Re: **lots 2C, St. Joseph Hospital Complex**
Request for DRB Approval- Amend Site Development Plan for Building Permit
COA Project #1009234, 12EPC 40032

Project# 1009234
12EPC-40032 Amend Site Development Plan for
Building Permit

for all or a portion of Lot 2C, St. Joseph Hospital
Complex, located on High Street, between Lomas
Boulevard and Fruit Avenue, containing
approximately 3.2 acres. (J-15)
Randall Falkner, Staff Planner

B3 AMENDMENT TO SITE DEVELOPMENT PLAN FOR BUILDING PERMIT

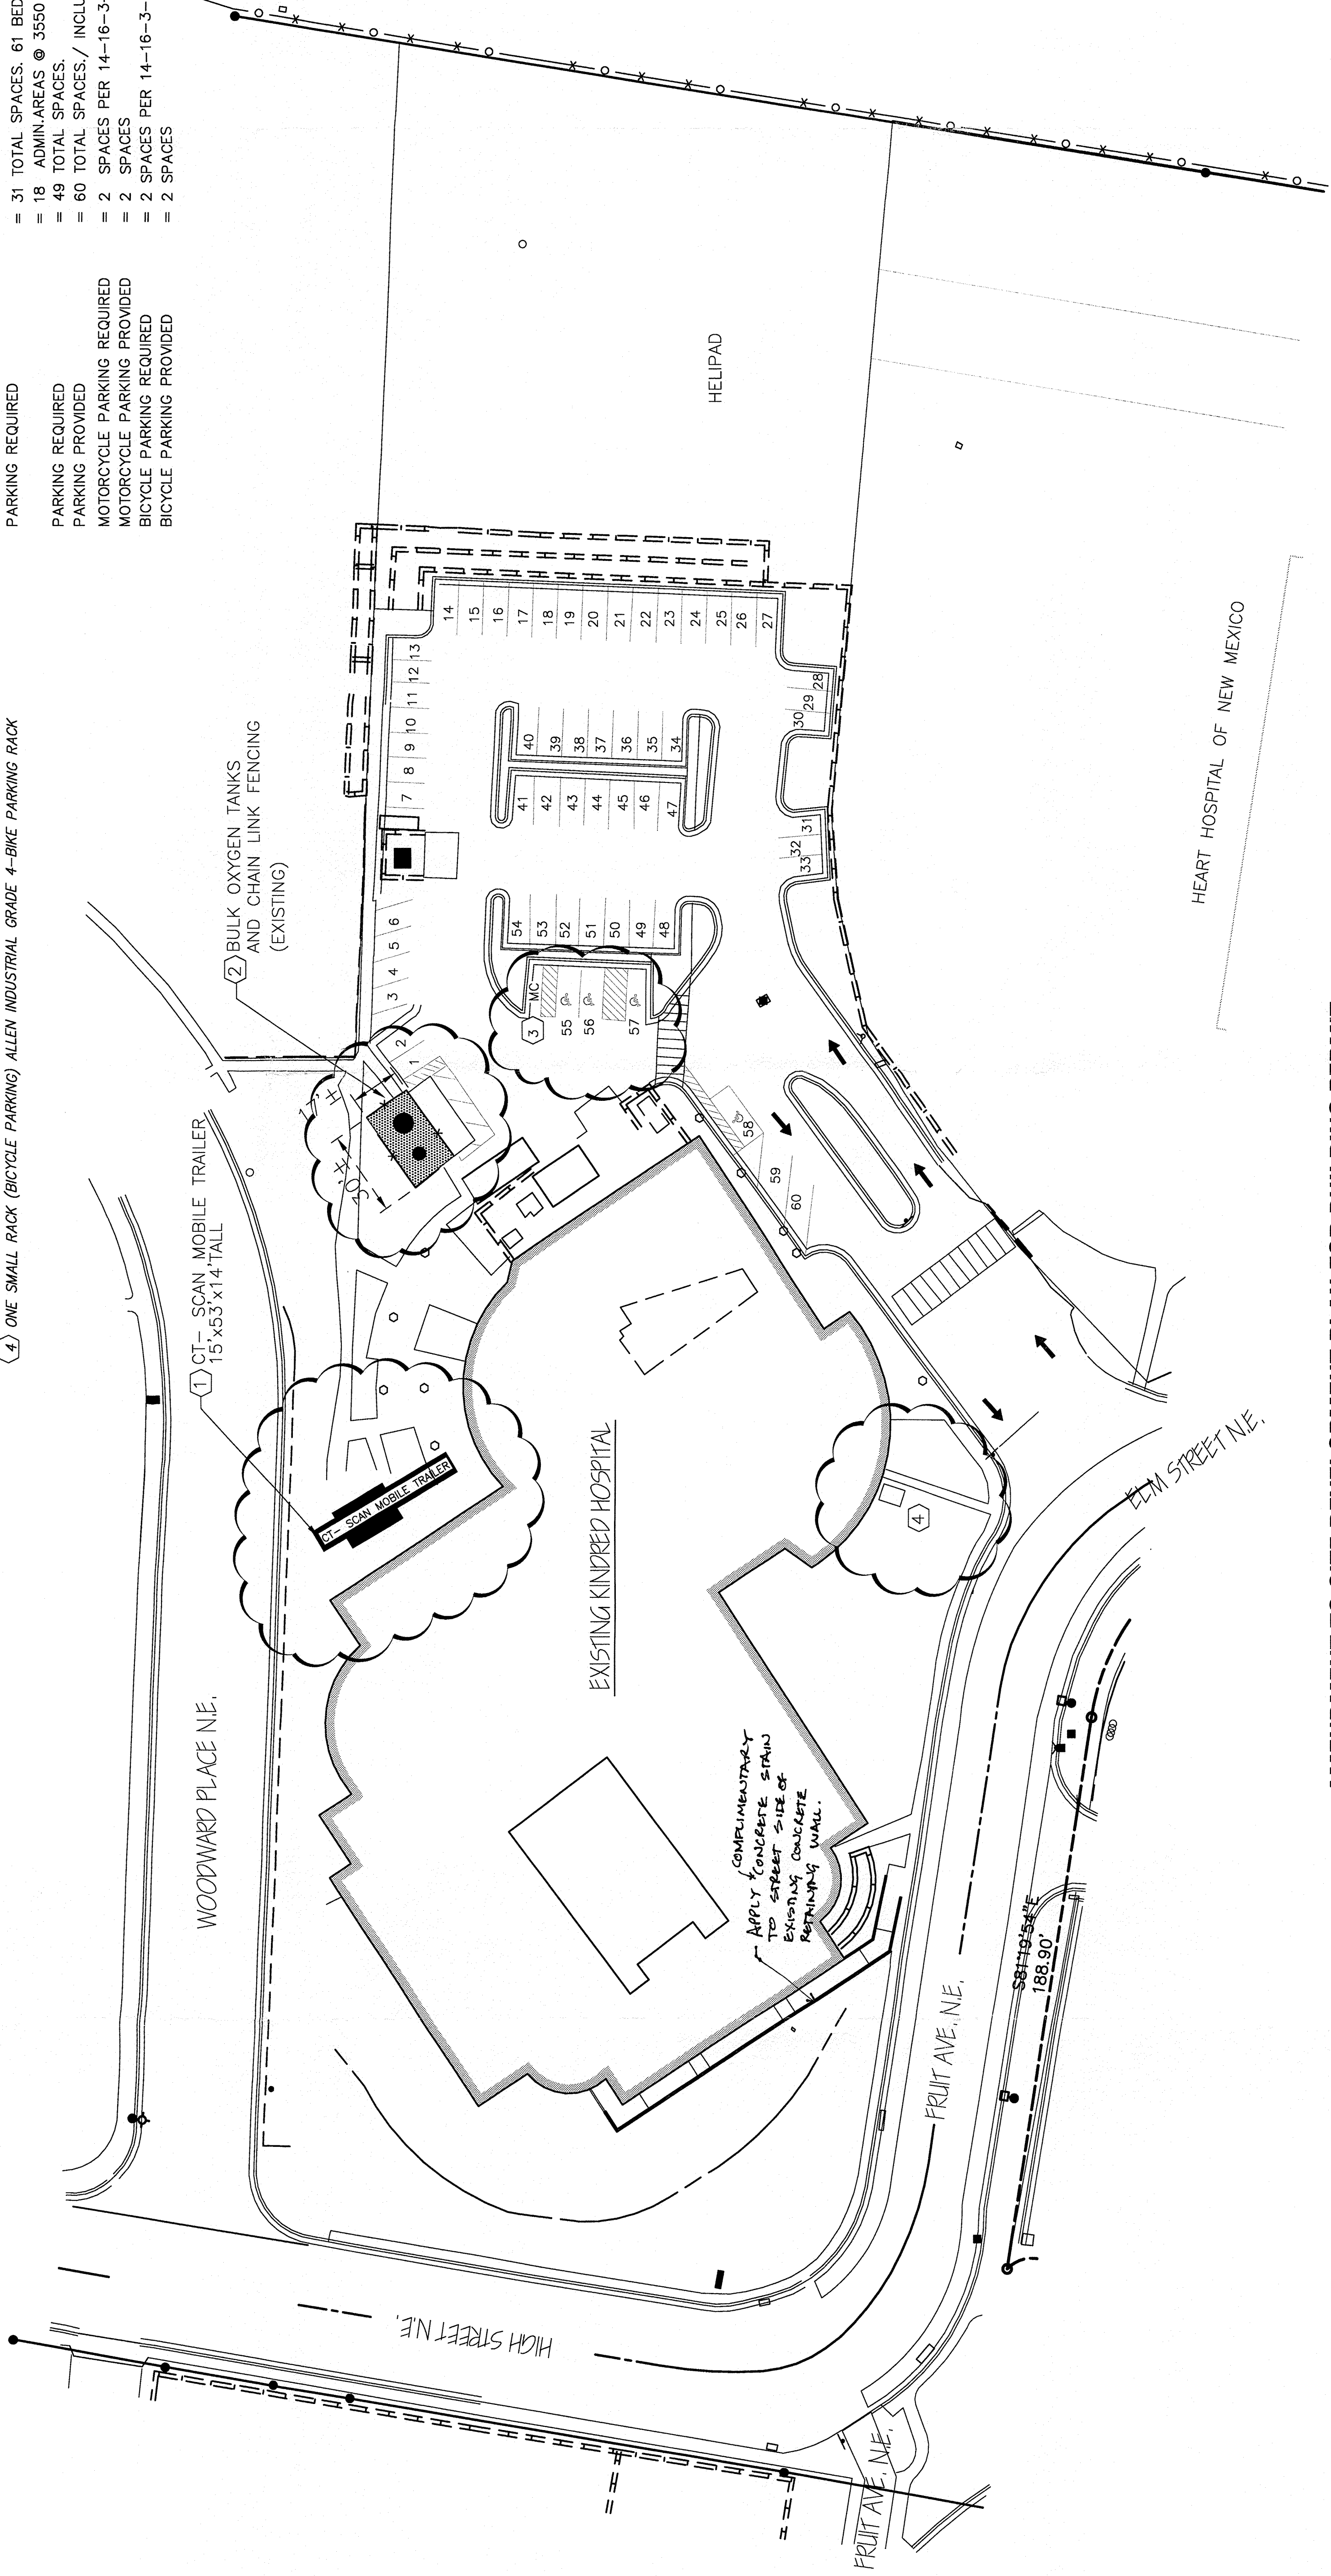
5. The handicapped ramp retaining wall along the west side of the building shall be a concrete stain to complement the building.

The staining of the western ramp has been added to the plans.

Sheet Title:
Landscape
Plan

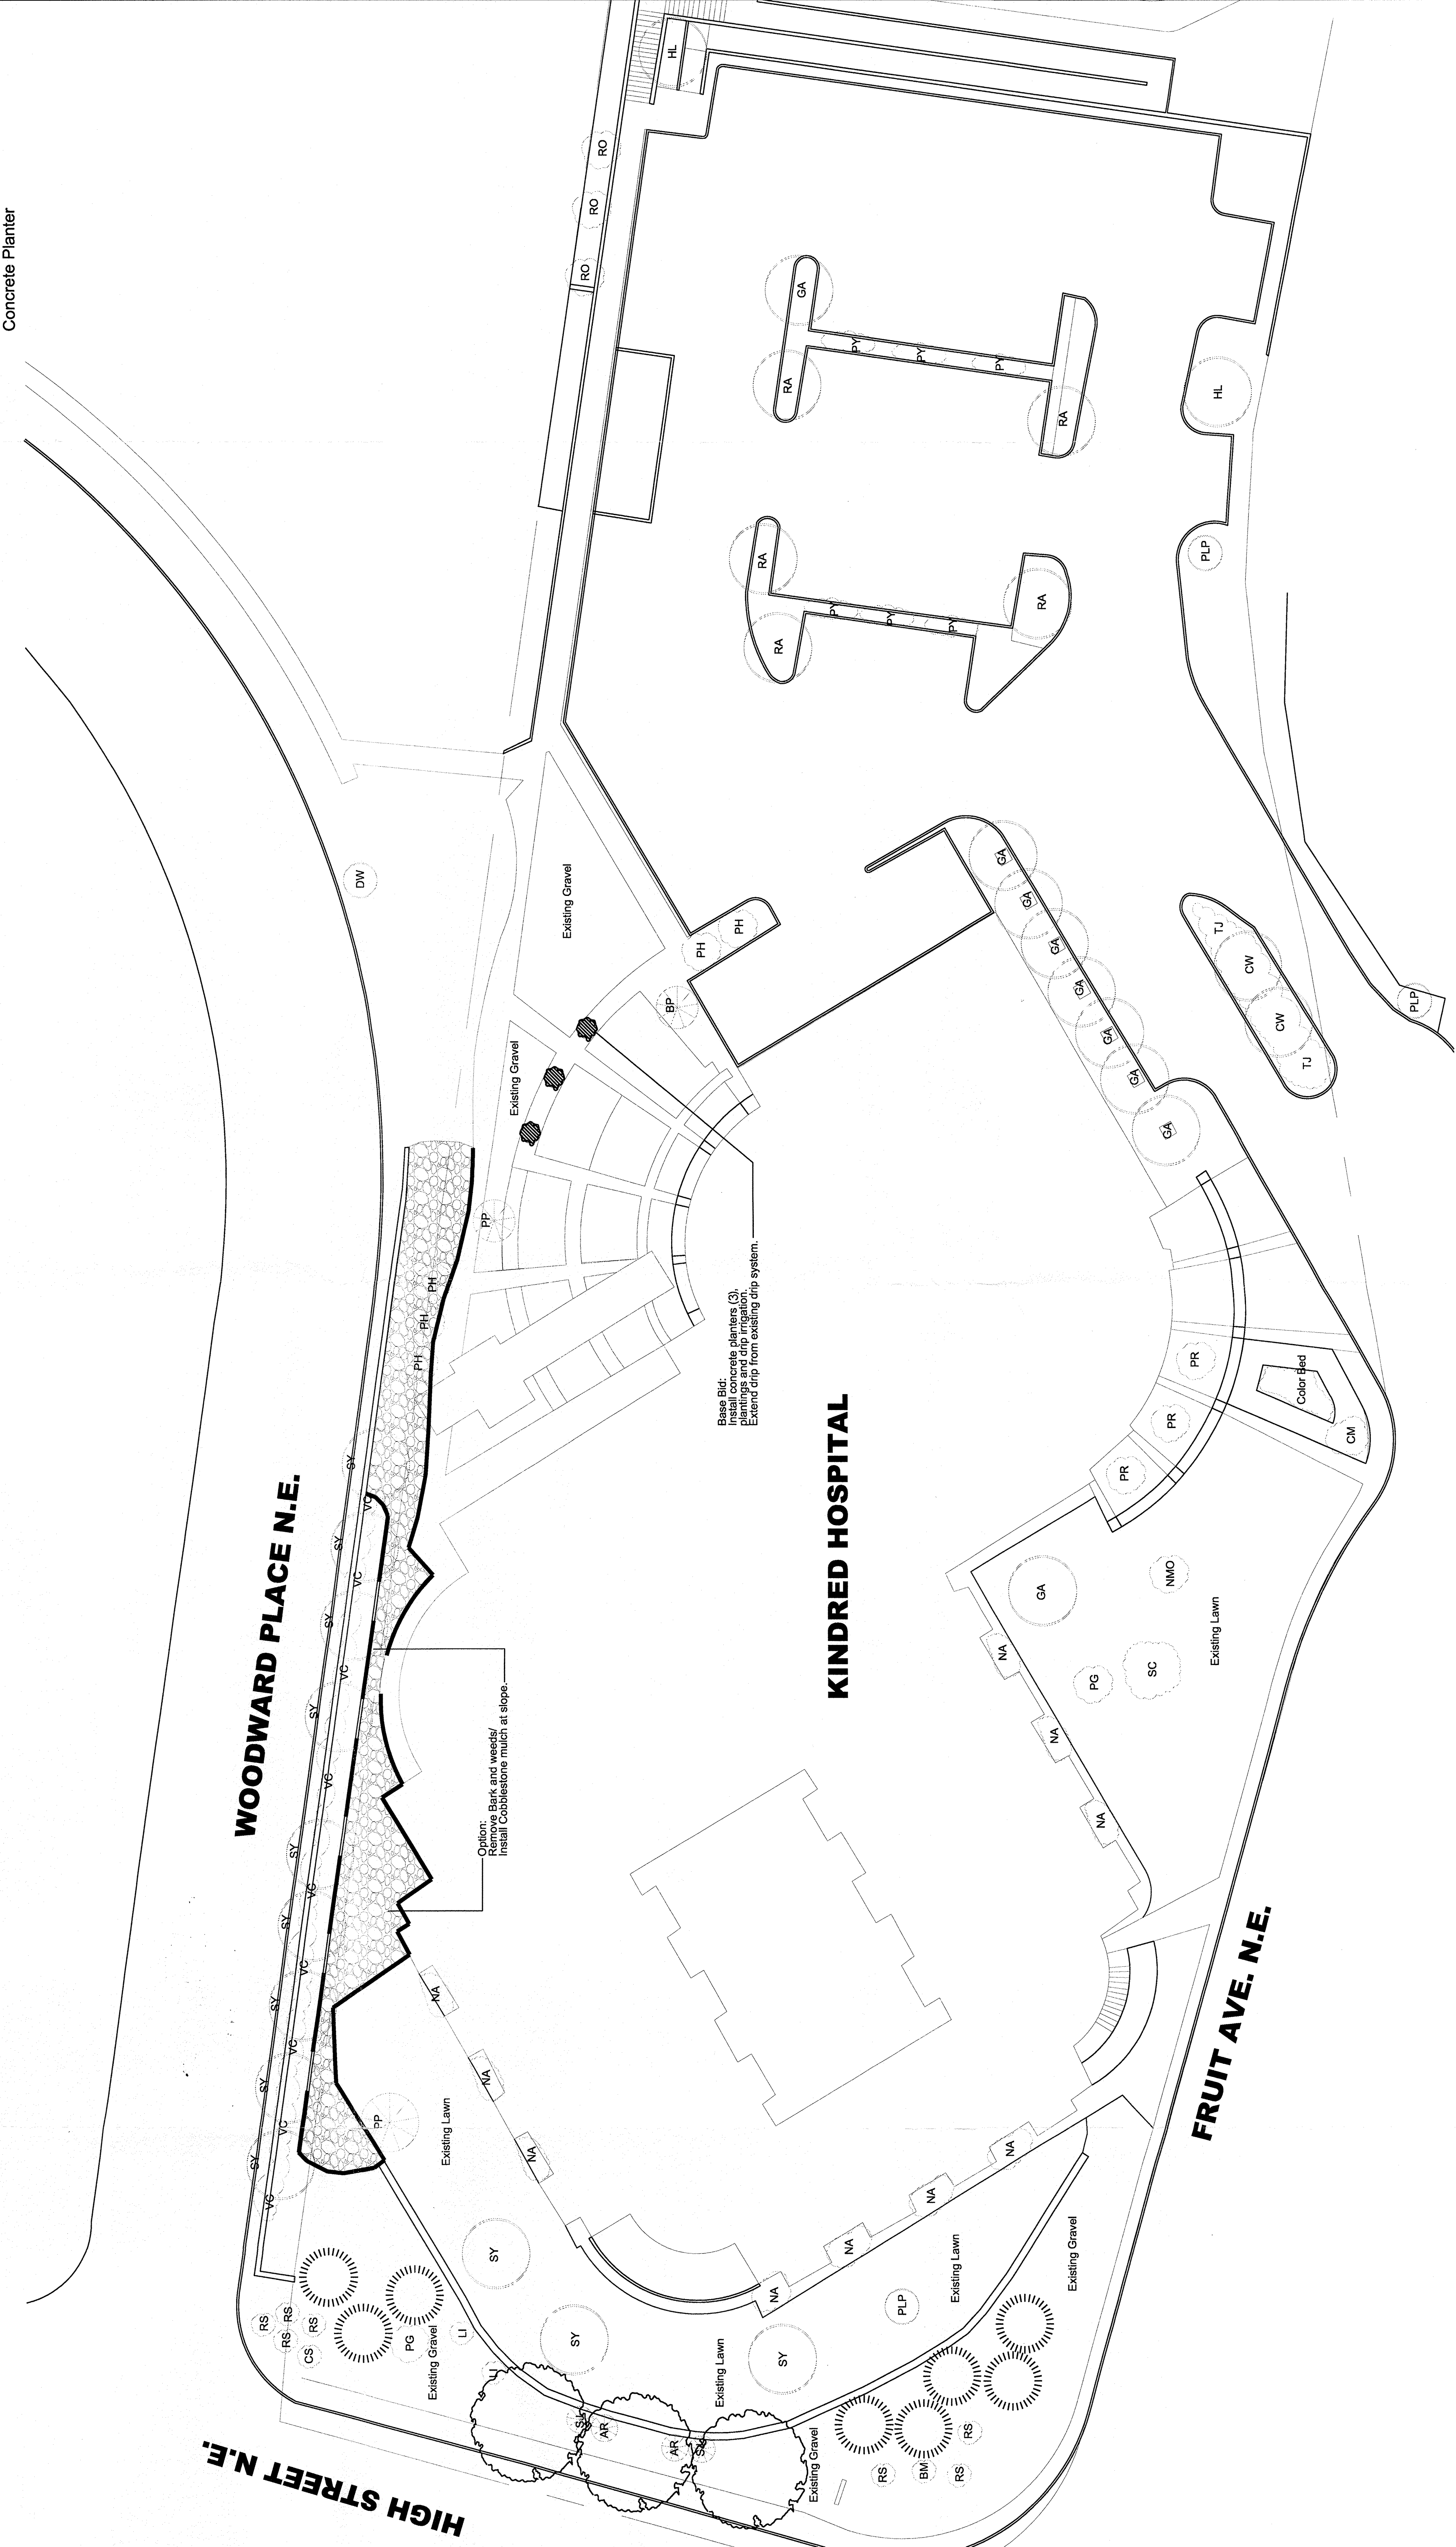
- a. Additional landscaping (which shall consist of a combination of trees and bushes that are consistent with the existing landscaping on the St. Joseph Medical Center Campus and Kindred Hospital and that preferably are low water use) shall be added to help screen the oxygen tanks and the mobile CT scanner from the properties to the north.

- b. The landscaping plan for Kindred Hospital needs a plant legend that shows quantity, symbols, scientific and common name, existing and mature size, and water use of all landscaping.

- c. Additional landscaping (including trees) shall be added to the west side of the Kindred Hospital property.
4. Condition of approval from Public Service Company of New Mexico: It is the applicant's obligation to determine if existing utility easements cross the property and to abide by any conditions or terms of those easements.

Landscaping should not be installed around the oxygen tanks. We are attaching the regulations for any combustible materials that may be located around oxygen tanks. With these limitations we do not feel that adding screening around the oxygen tank is an option. If we stay back from the tanks as required the landscaping improvements would actually be in the City ROW and not on the property.

A plans Legend has been added to the plan to identify the new plantings proposed with this project.

The adjacent neighborhood had requested that the west side of the hospital receive more landscaping. The proposed plan has added both deciduous and coniferous trees along that edge.
